Consultation Response from KC Highways Development Management		
2026/90527 31 Cow Heys, Dalton, Huddersfield, HD5 9RG		
Erection Of Front Porch		
Date Responded: 08/04/26	Responding Officer: M Zenner	Responding Ref: 11-3SW/19
RECOMMENDATION: No objection to the proposals subject to compliance with Kirklees Dropped Kerbs guidance. The provision of the extended dropped kerb will be subject to the successful outcome of a Section 184 application to Kirklees Council.		
Development Overview:		
The application description states that the application is for the erection of a front porch. However, the submitted plans indicate the widening of the drive across the majority of the site frontage to increase the parking space available for the property, with a landscaping border located along the western boundary of the property. The property is located on Cow Heys, an unclassified road subject to a 30mph speed limit.

Proposed Elevation , Site and Floor Plan			
31 Cow Heys			
Dalton			
Huddersfield			
HD5 9RG			
Date	February 2026	Dwg no	02
Dwn By	-----	Scale	A3 - 1:100

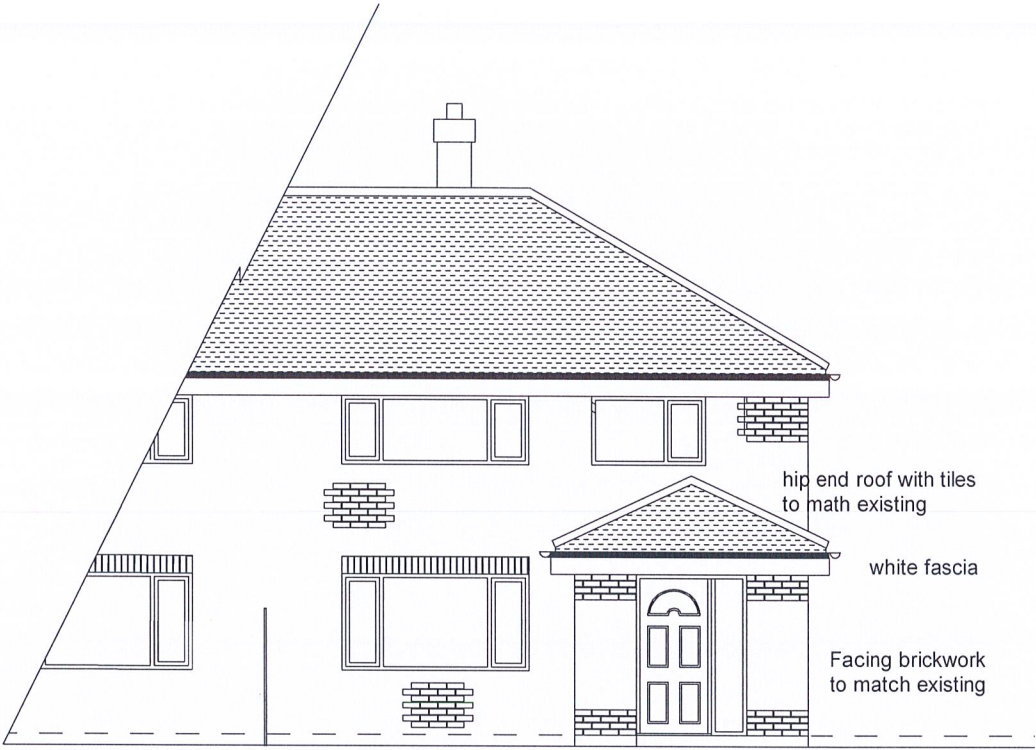
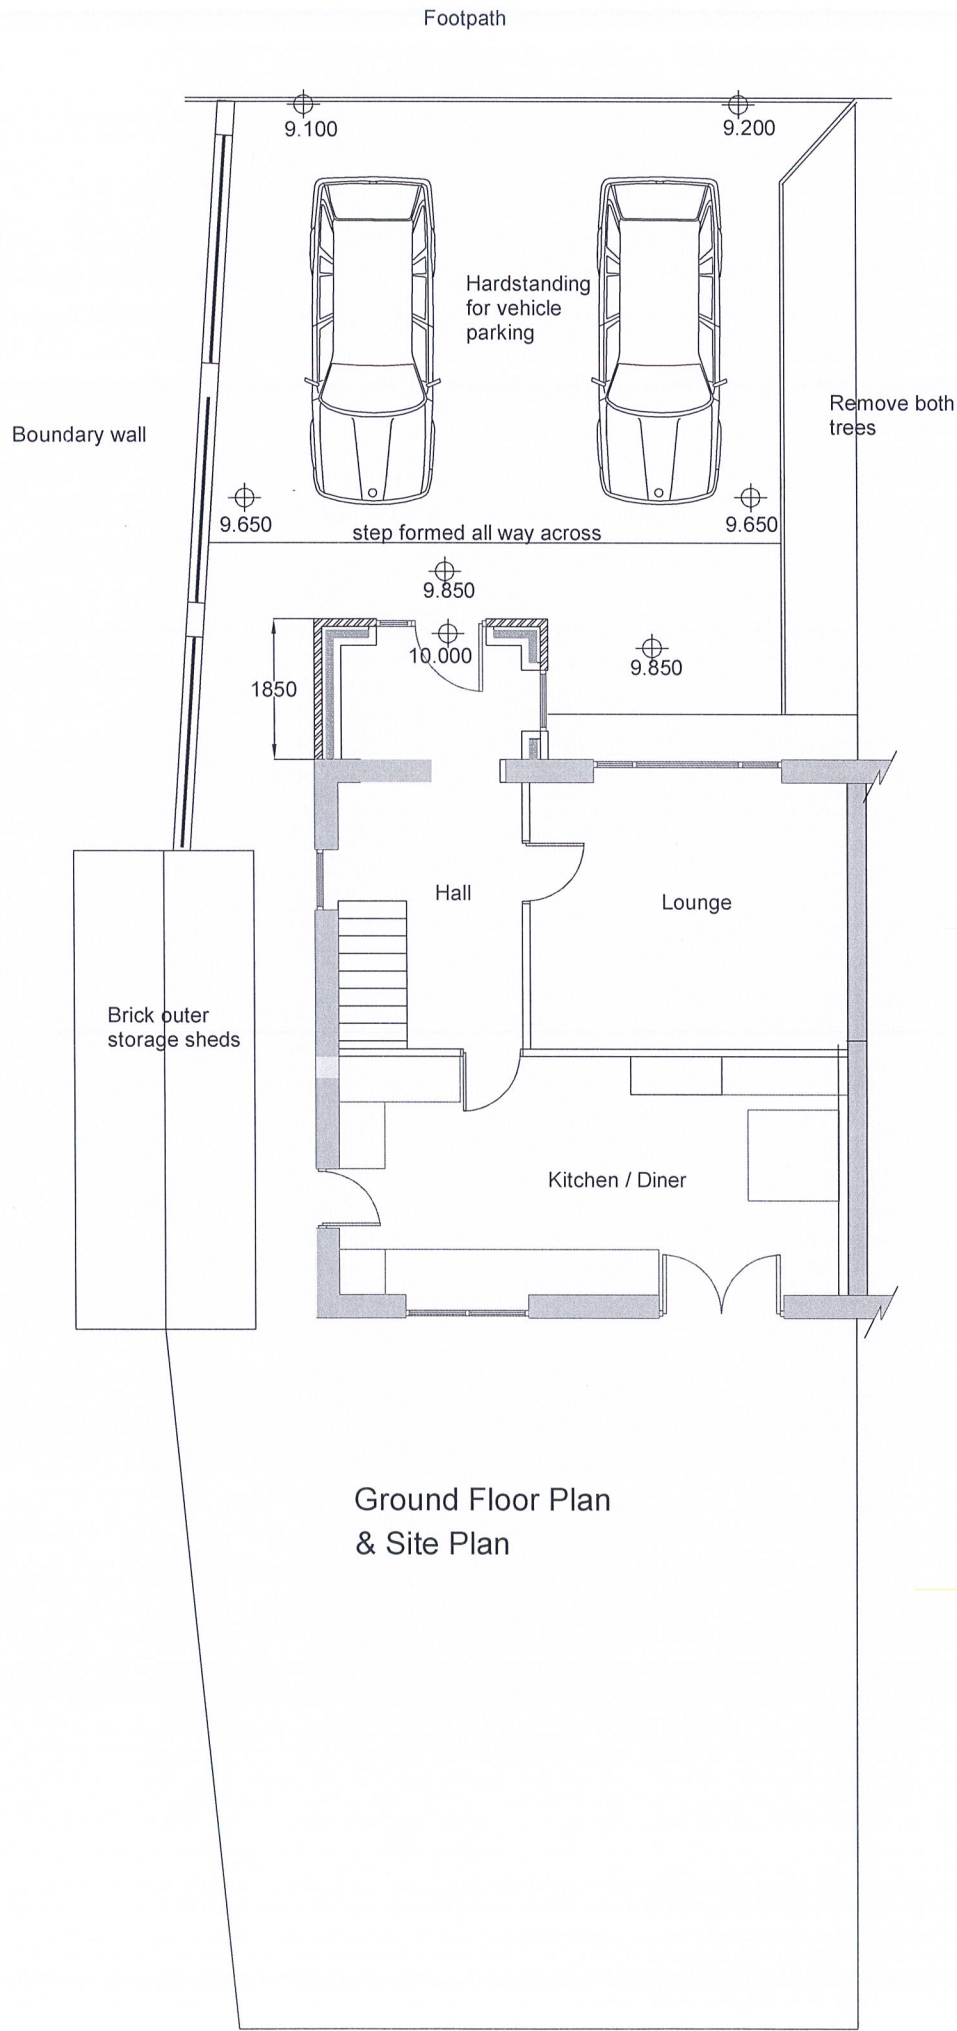
Reference to Plans/Documents:		
➤ Application Form; ➤ Proposed elevation, site and floor plan – Dwg no 02; ➤ Existing elevations and floor plans – Dwg no 01; ➤ Location Plan – UK Planning Maps		
Policy:		
Local Plan Policies – LP5, LP19, LP20, LP21, LP22, LP23, LP24; Kirklees Highway Design Guide SPD; Kirklees Dropped Kerbs Guidance.		
Vehicular Access:		
At present there is an existing boundary wall interspersed with railings along the site frontage, which is adjacent to a pedestrian access gate and a vehicular access gate, both of which open inwards. Whilst the application description states that the proposals are for the erection of a front porch, the LHA also notes the proposed plan shows hardstanding for vehicle parking for across approximately 7.3m width of the frontage. The boundary wall and gates appear to be removed and there is approximately 6.7m length available between the proposed porch and the site boundary. The existing boundary treatment to the east side of the site appears to be of brick construction with timber panels which appears to be higher than 0.6m. Manual for Streets states that drivers need to be able to see obstructions from 2m high down to a point 600mm above the carriageway. The latter dimension is used to ensure small children can be seen. Ideally pedestrian visibility splays of 2m x 2m should be provided at either end of the proposed driveway.

However, it is accepted that the arrangements are existing on the eastern boundary and there is a planting area proposed on the western boundary of the site which should afford visibility of pedestrians approaching from the west.

The Kirklees Highway Design Guide states that any parking surface located immediately in front of a property should be permeable, bonded/ interlocking and preferably finished with a natural material.

Furthermore, before it can be constructed, the parking area / driveway must have a way of preventing surface water from flowing onto the public highway to comply with Section 163 of the Highways Act 1980.

Whilst there are no objections in principle to the proposals on highways grounds the proposed plan demonstrates an amended / widened vehicular access to the property which would need to be secured from Kirklees Council in accordance with Section 184 of the Highways Act 1980. Full details of the application process are detailed here: [Dropped kerbs | Kirklees Council](#)

Conclusion: No objection to the proposals subject to compliance with Kirklees Dropped Kerbs guidance. The provision of the extended dropped kerb will be subject to the successful outcome of a Section 184 application to Kirklees Council.
